From: Sue Howell
Sent: 22 March 2018 15:54
To: Simon Davis
Subject: RE: Further comment to Landscape Planning Consultation on P/1/18/DOC

APPLICATION NO: P/1/18/DOC

Site Address: 251 Pagham Road & Land R/O Pagham PO21 3QB

Description of Works: Application for approval of details reserved by conditions imposed under planning permission P/125/14/PL relating to condition No. 10 (Refuse & recycling bins), condition No.14 (Visitor Parking Spaces), condition No.15 (Surface water onto Highway), condition No. 16 (Street Lighting), condition No. 18 (Cycle Parking), condition No. 21 (Landscaping), condition No. 22 (Screen Walls & Fences) & condition No.26 (External Lighting), condition 31 (Dog Walking)

drawing title	Landscape General Arrangement (East)				
drawing no.	1896-TF-00-00-DR-L-1002				P03
scale	1:250 @ A1	date	28.09.17	drawn by	AC
				checked by	AC

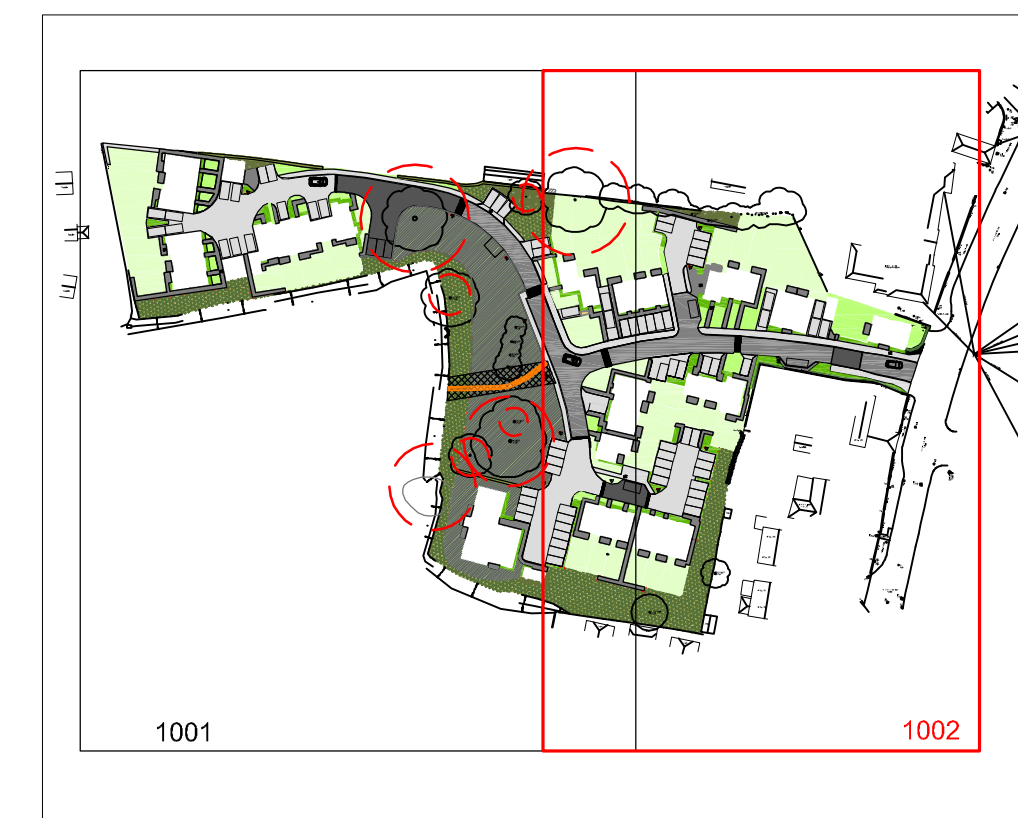
Whilst the DOC application P/1/18/DOC has complied in that it has provided detail of a scheme of landscaping both hard and soft which was the requirement of condition 21, which is adequate in what it is proposing in terms of species type densities and size at time of planting; further reading and agreement with Pagham Parish Council (at the time of application P/25/14/PL) indicates an agreement in principal was to bolster and provide further landscape buffer and reptile translocation zone to the east and south eastern corner of these proposals.

My initial view is that the trees being proposed along the eastern area would be adequate in species choice for this location (to the east) in providing good biodiversity and habitat enhancement without swamping the area and causing future light issues to those properties to the east. The understory here is shown to be wildflower EM4 which would also be suitable and in consideration of habitat, however the ground cover planting shown to the edge of the carpark is ornamental in nature and will not provide a screening buffer. **I conclude that if the agreement in principal as appears to be, was for enhancement in width and height of landscape buffer to the rear of Pagham Road dwellings then this has not been achieved and therefore I would retract my recommendation for discharge of condition 21 because of this reason and request that further appropriate buffer screening to be proposed in this area.**

"The Structural Planting along the east boundary is completely inadequate as requested by the Parish Council and individual objections to P/125/14/PL. Proper screening of development is required not token planting"
